30 September 2020
Our Ref: 9809A.15PS_s4.55(1A)_Mod 2

**RE: SECTION 4.55(1A) APPLICATION TO MODIFY SSD 8365 (MOD 2)
PENSURST PUBLIC SCHOOL
510 FOREST ROAD, PENSURST**

PENSHURST PUBLIC SCHOOL
18 Arcadia Street, Penshurst
ELEVATIONS - SHEET 2

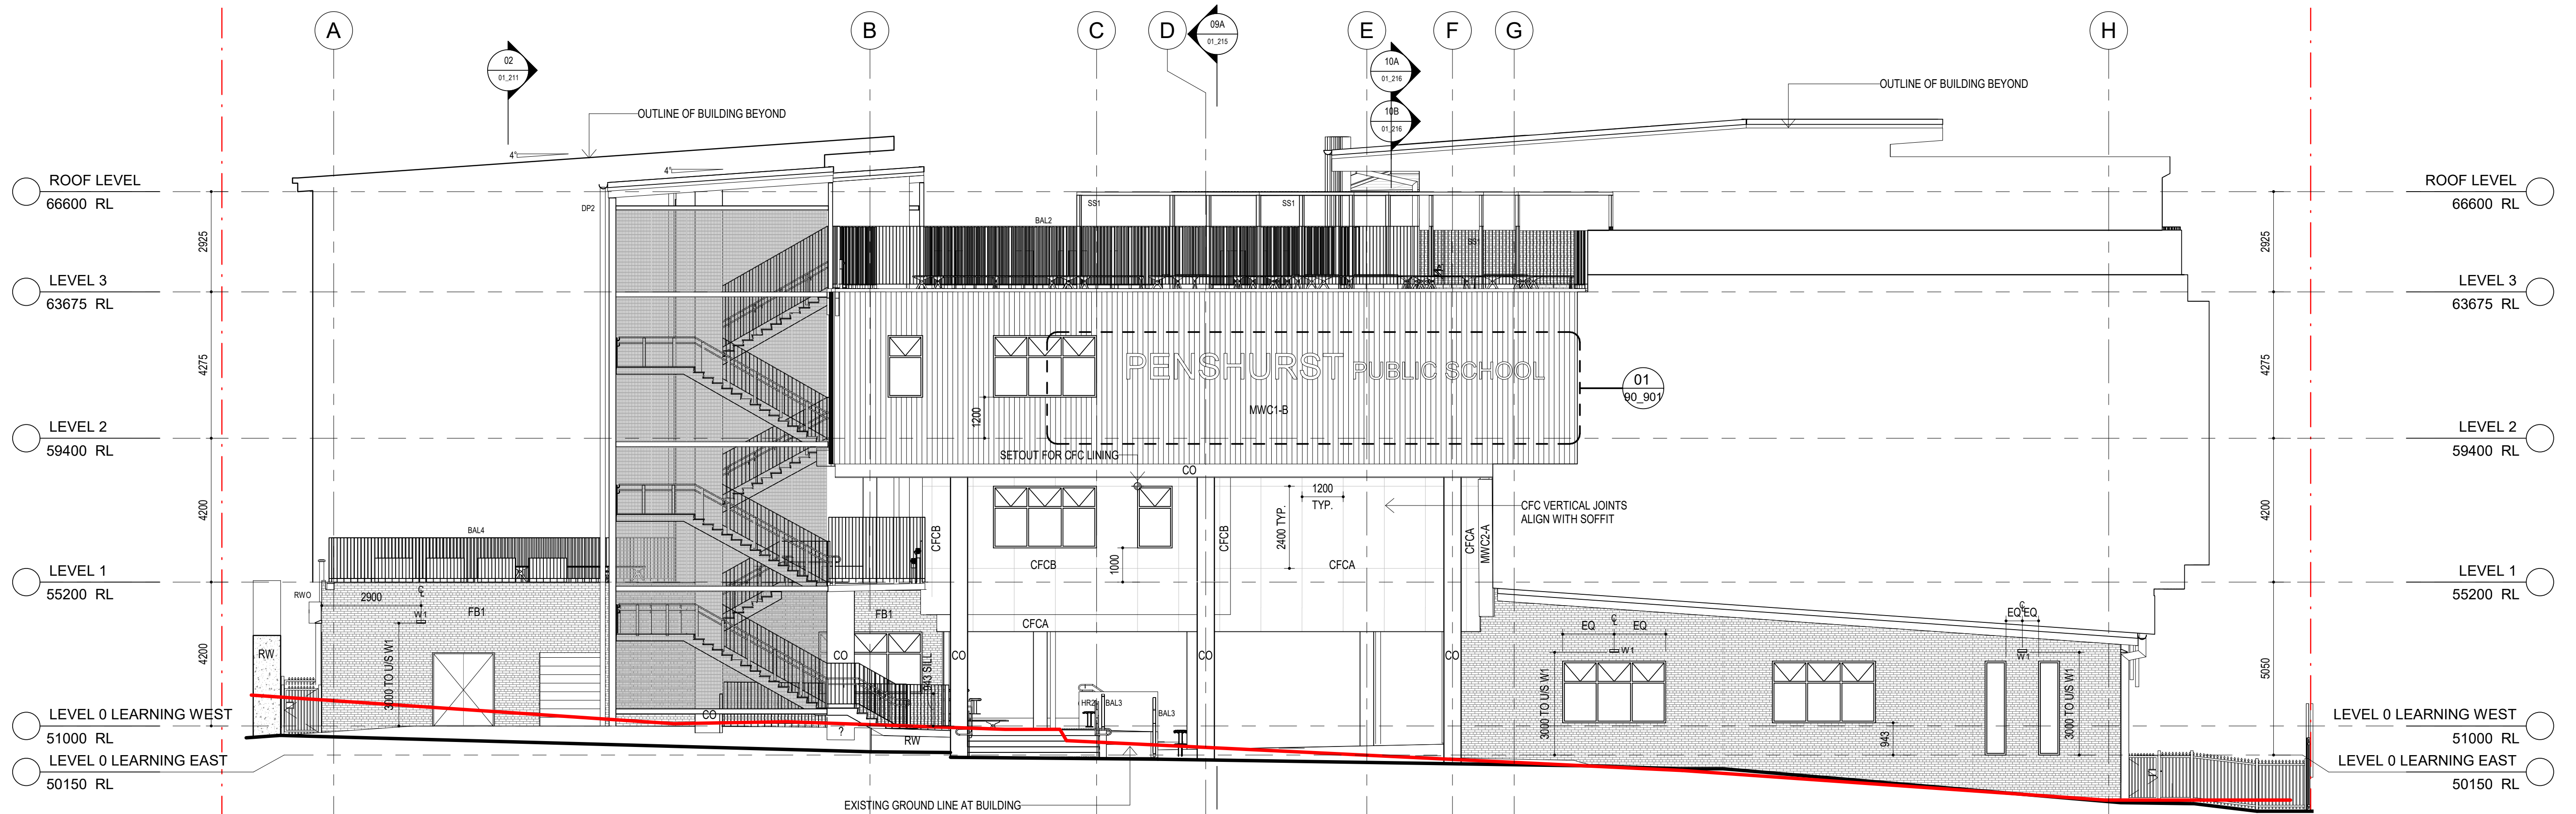
- Increase turfed area, decrease astro turf and re-align pathway and drainage (see **Dark Blue** mark up in **Figure 2**);
- Amend planting locations for ten (10) Crepe Myrtle (*Lagerstroemia* 'Natchez') trees (see **Orange** mark up in **Figure 2**) with no change to total number of plantings;
- Change tree species along boundary to Lilly Pilly (*Acmena smithii* 'Redhead') in order to limit crown spread and reduce overhanging branches over boundary (pursuant to discussions and agreement with neighbours) (see **Light Blue** mark up in **Figure 2**);
- Install new double gate to allow access for Fire Brigade (see location identified in **Pink** in **Figure 2**); and
- Extend brickwork to roof line on northern façade (see **Red** bubble in **Figure 3**).

The only change to the built form is a small extension of the approved brickwork to the roof line on the northern façade, proposed to address waterproofing of the gap between the roof and the metal clad finish that was originally intended to extend down past the roof line, as approved. The modification is minimal and will not result in any change to massing or structure of the building. Accordingly, further assessment of the visual impact is not warranted in this regard.

PENSHURST PUBLIC SCHOOL
18 Arcadia Street, Penhurst
LANDSCAPE SITE PLAN NORTH

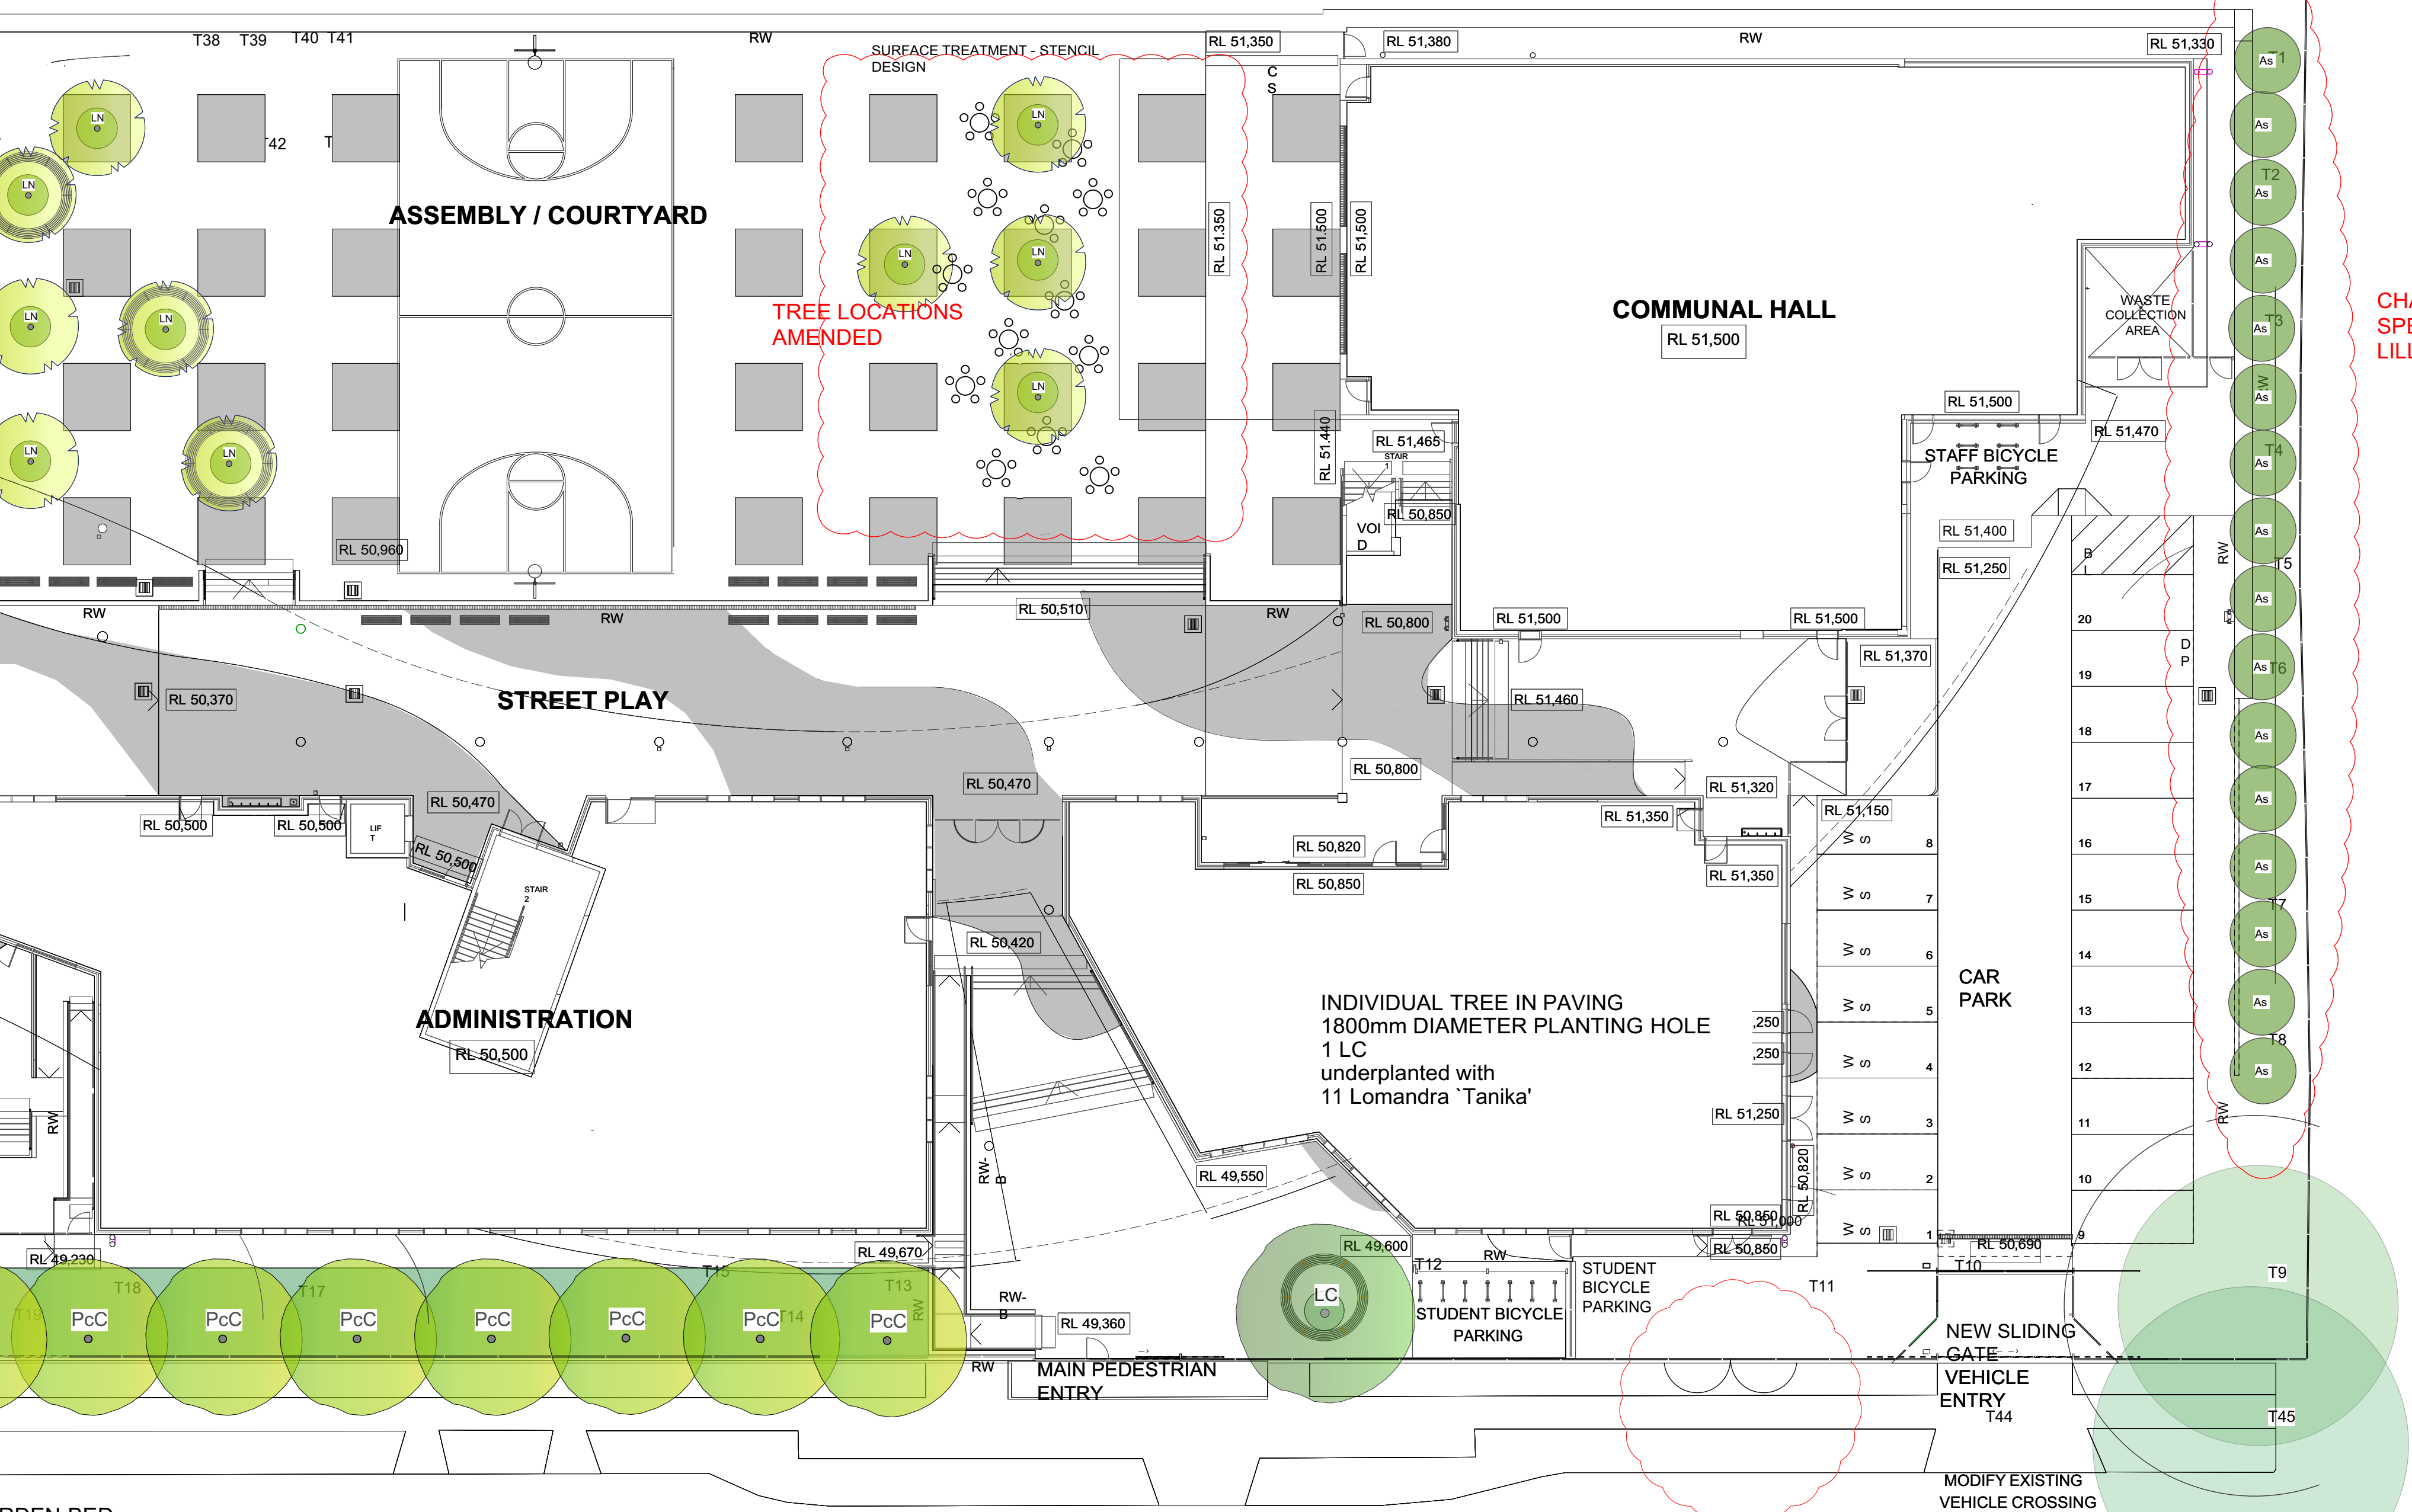
The modification to tree species along the northern boundary is in response to discussions with the neighbour about minimising branch overhanging by changing the tree species with a screening hedge which achieves the height and privacy without the crowning tree spread over the neighbouring properties. The modifications will reduce the number of plantings along the northern boundary from 22 to 16, however these have been increased in pot size from 45L to 100L to achieve earlier screening.

PENSHURST PUBLIC SCHOOL
18 Arcadia Street, Penshurst
OVERALL SITE FENCE PLAN

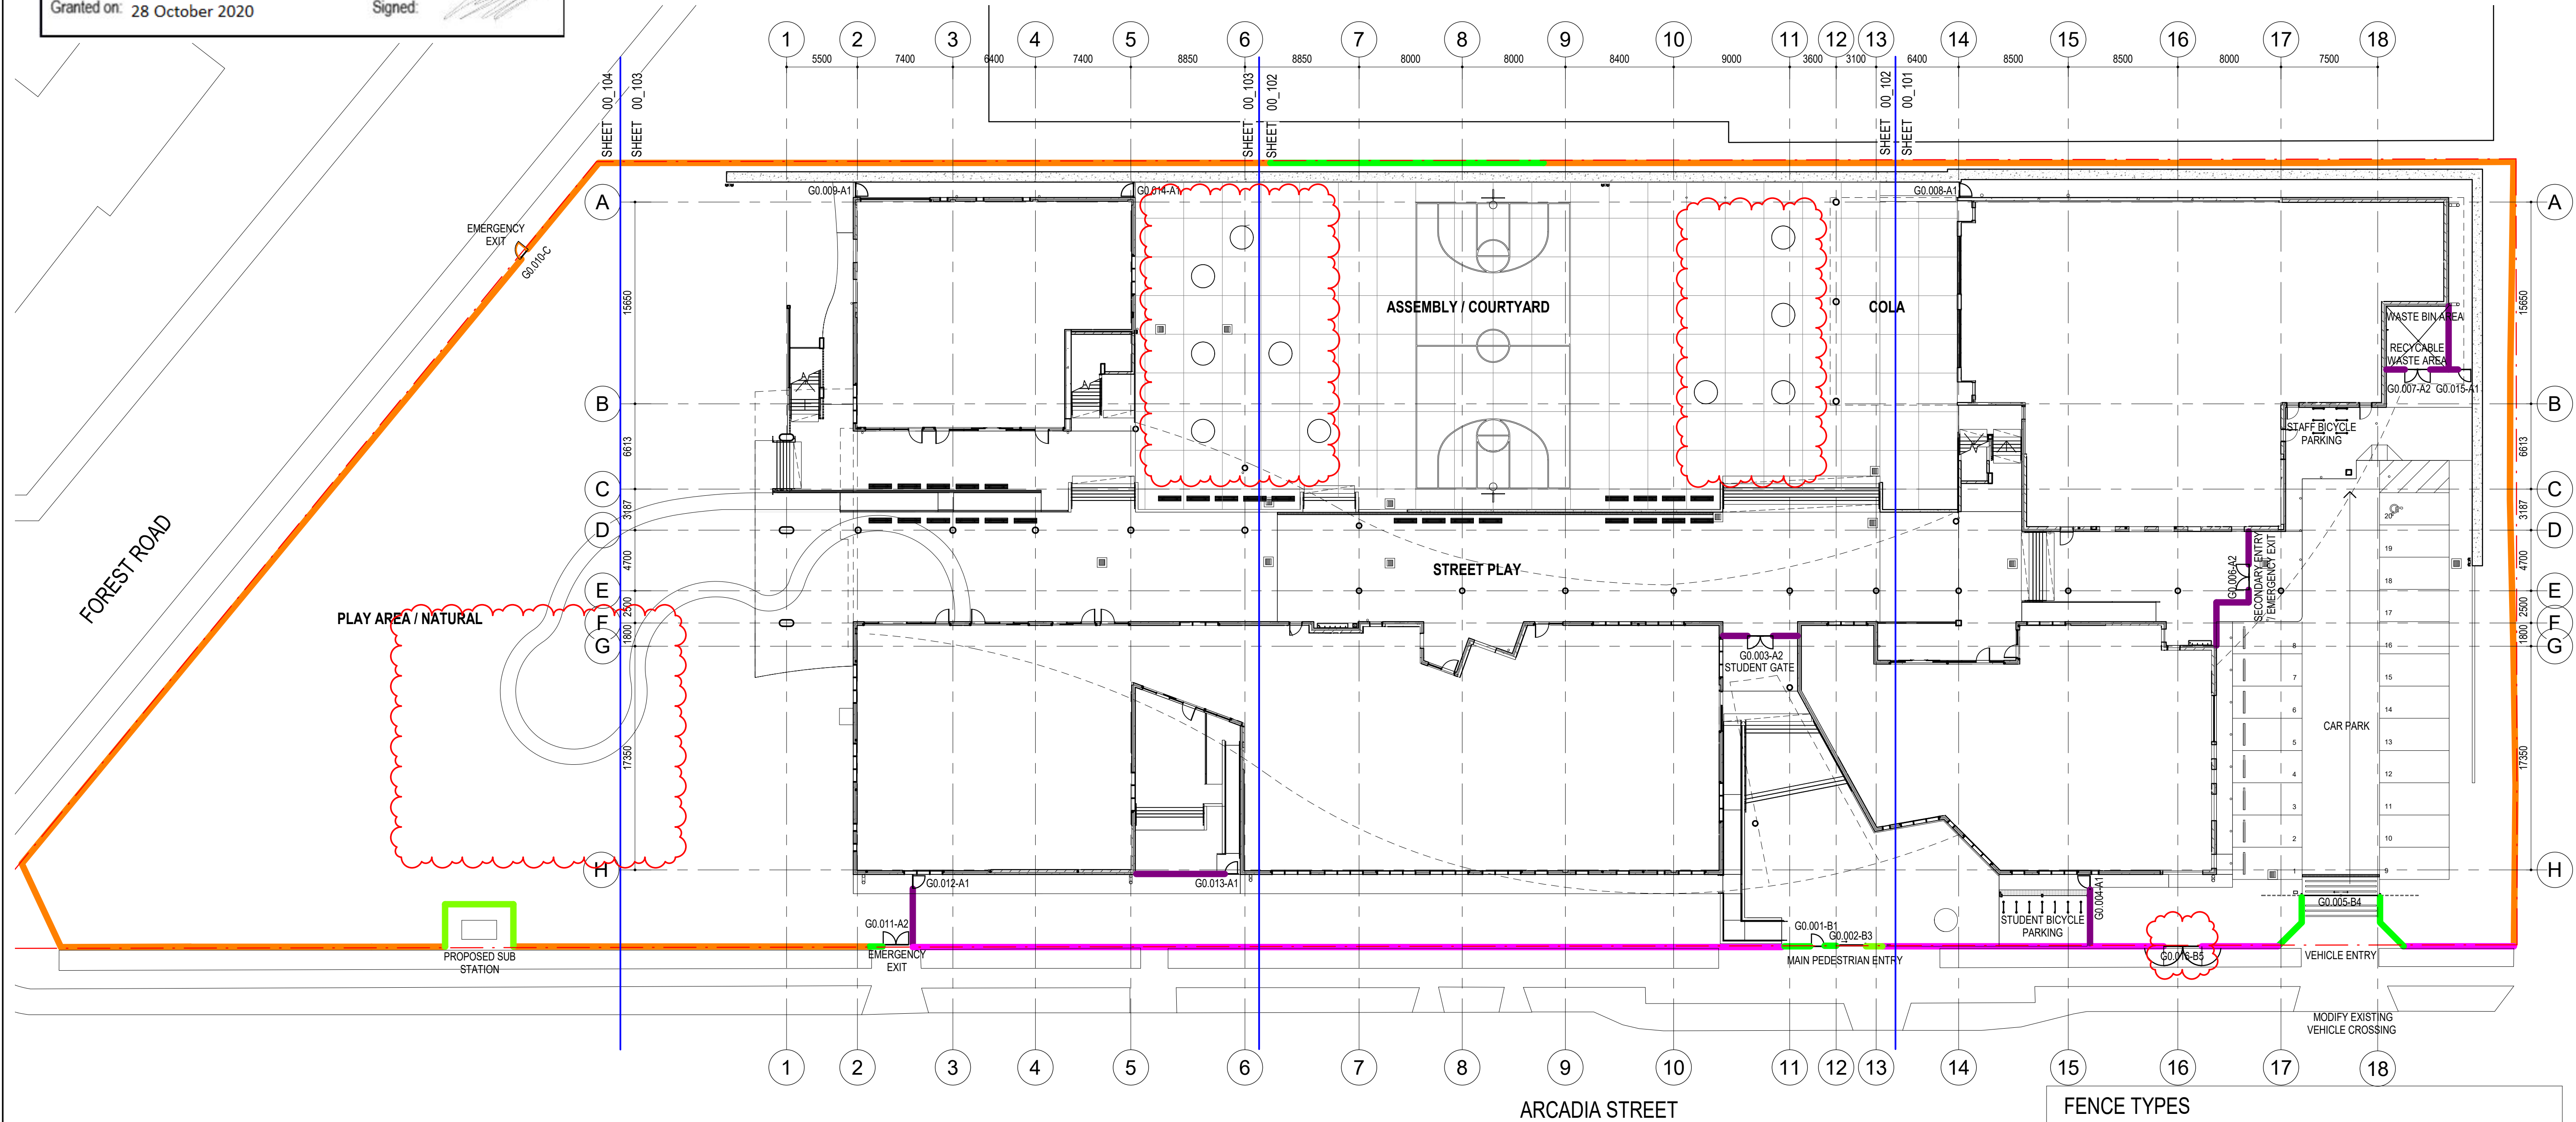
The section 4.55(1A) application (Mod 1) seeks to modify Condition A2 relating to the approved plans in order to facilitate minor amendments to plans including adjustments to landscaping, extending the face brick work to roof line on the northern elevation to address water proofing issues, and installation of a double gate to the perimeter fence for Fire Brigade access.

The proposed modifications will result in minor amendments to the landscaping layout and a change in species located adjacent to the northern boundary, both responding to school and neighbour feedback. The installation of the gate to enable access for the Fire Brigade will improve safety for students and staff in the event of a fire. Built form changes will not be discernible from the approved built form and will therefore result in little to no visible change to the approved development from the public domain. Accordingly, the modifications are considered to be in the public interest.
